**Consultation Response KC Landscape**

<b>Planning Number:</b>	2023/90035		
<b>Proposal:</b>	Discharge conditions 3,4,5,10,12,13,14,15,16,18 on previous permission 2021/94165 for erection of four dwellings with ancillary garages and associated landscaping works (within a Conservation Area)		
<b>Location:</b>	Land adj, 7, West Lane, Gomersal, BD19 4DL		
<b>DEVELOPER/APPLICANT/AGENT:</b>	John Marriott		
<b>Planning Officer:</b>	Craig Hewitt		
<b>Date Responded:</b>	13.04,2023	<b>Responding Officer:</b>	Michelle Stevens
<b>Site Area (Hectares)</b>		<b>Responding Ref:</b>	MM26

**NOTES/COMMENTS:**
**COND 18 - Landscaping**

Tree planting scheme at:
West Lane, Gomersal

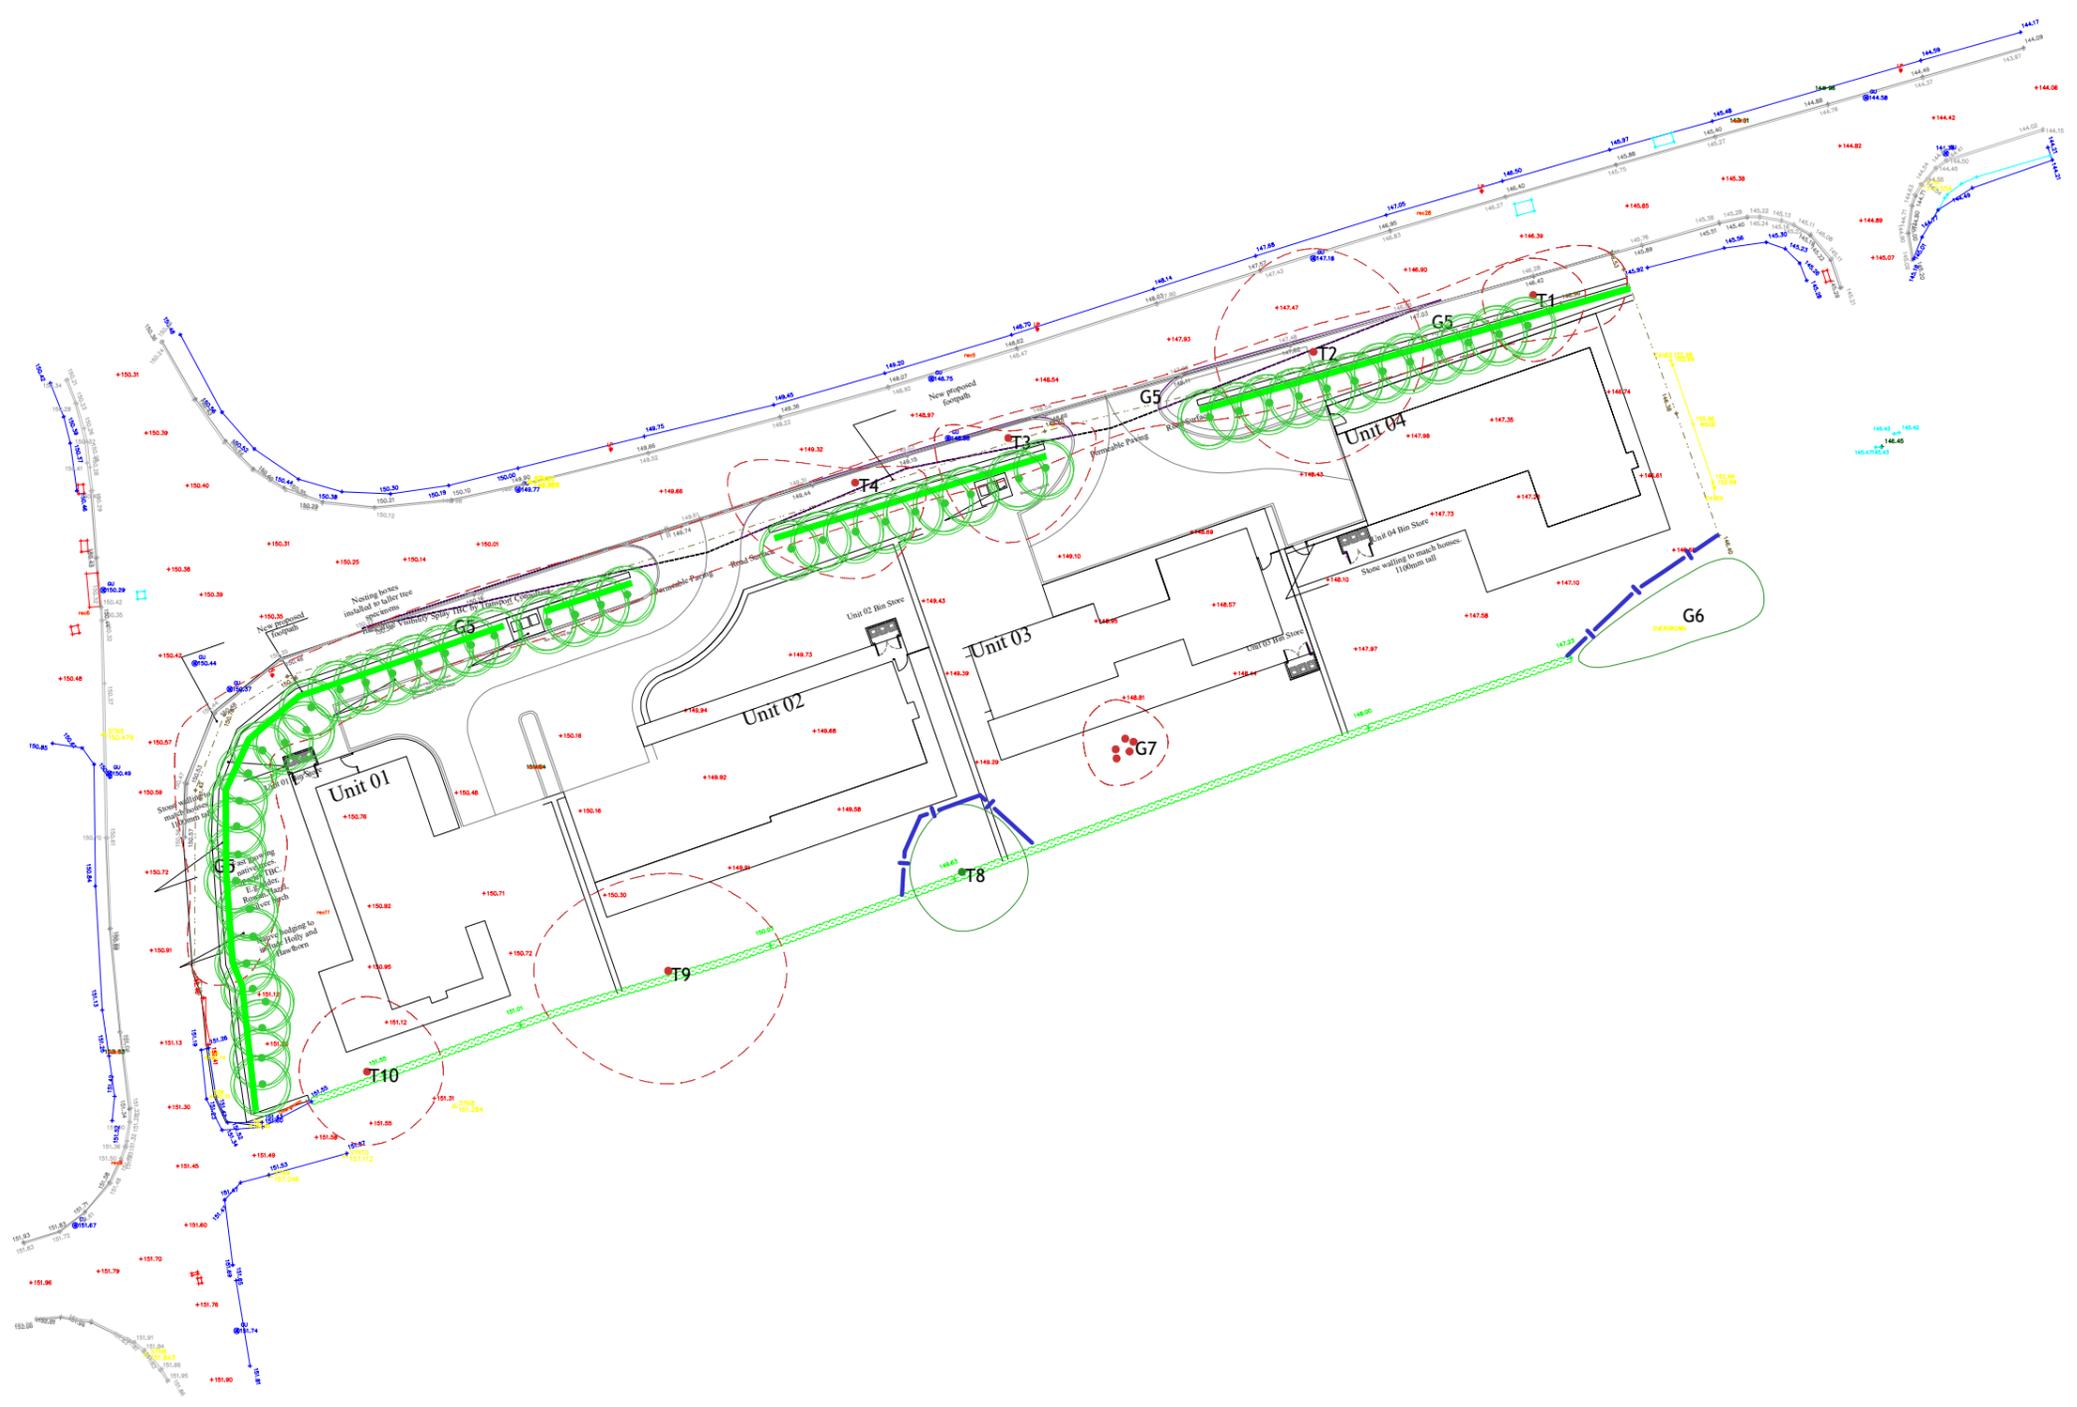
- Clarification as to which landscape plan is to be carried out. There are discrepancies between all 3 documents: Arb plan, BEMP and Landscape Plan. These need to correlate.

- Native hedgerow species mix to be confirmed (mixed species (PREFERRED) or hawthorn only) (whips)
- Native tree species: Betula pendula and/or Quercus robur (BOTH SPECIES PREFERRED) (standard size)
- The proposal needs to confirm:
